Tween Bridge Solar Farm

Environmental Statement Appendix 1.1: Planning Inspectorate's EIA Scoping Opinion

SCOPING OPINION:

Case Reference: EN010148

Document Reference: 6.4.6.3

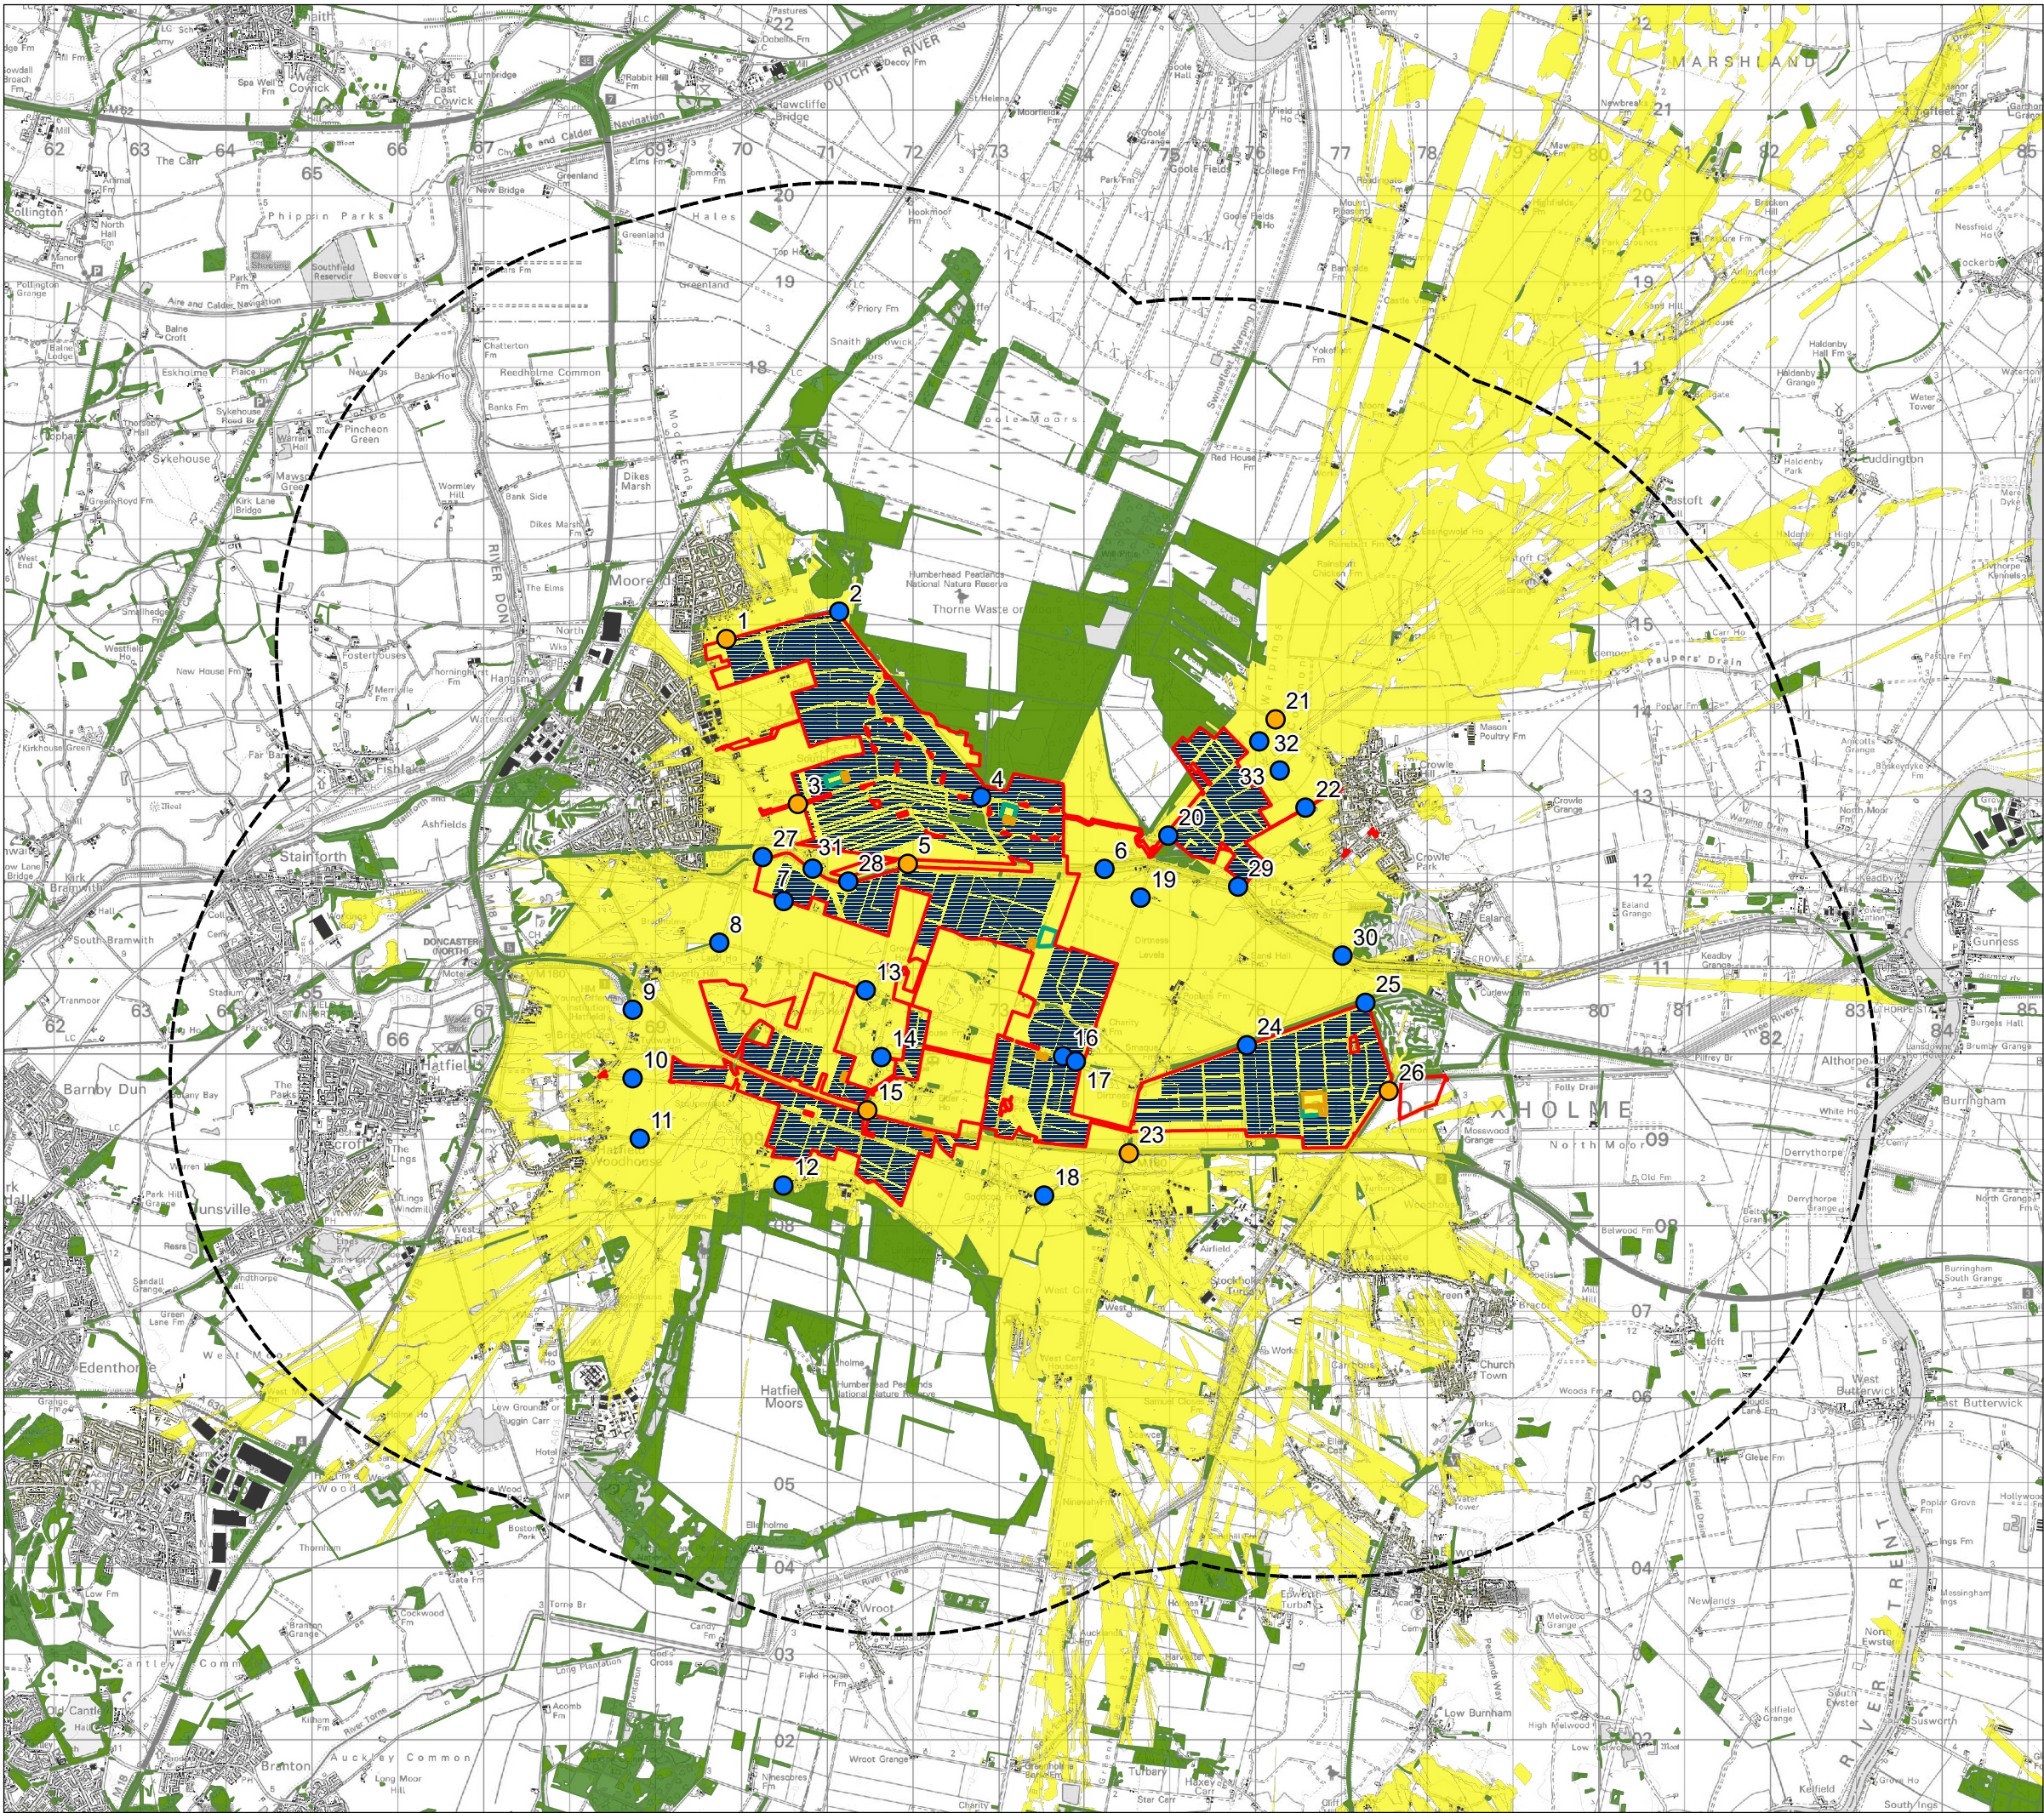
3.5.3	Para 4.31	Impacts	Paragraph 4.31 of the Scoping Report states that: "<i>The SZTV [Screened Zone of Theoretical Visibility, shown on Appendix 4.1 of the Scoping Report] has been run at an average height of 3m across the site for the elements which form the proposed development</i>". However, the Inspectorate notes that the anticipated height of the BESS, which is likely to be a prominent feature of the Proposed Development, has not been provided in the Scoping Report. If during the design evolution of the Proposed Development it is determined that the maximum parameters of any element will exceed 3m in height, the Applicant should re-run the SZTV and review the study area and identified receptors accordingly. The assessment of impacts to landscape and visual amenity (including the SZTV, study area and visualisations) should be based on the relevant worst-case having regard to any parameters applicable to the Proposed Development, including all proposed structures such as the BESS.
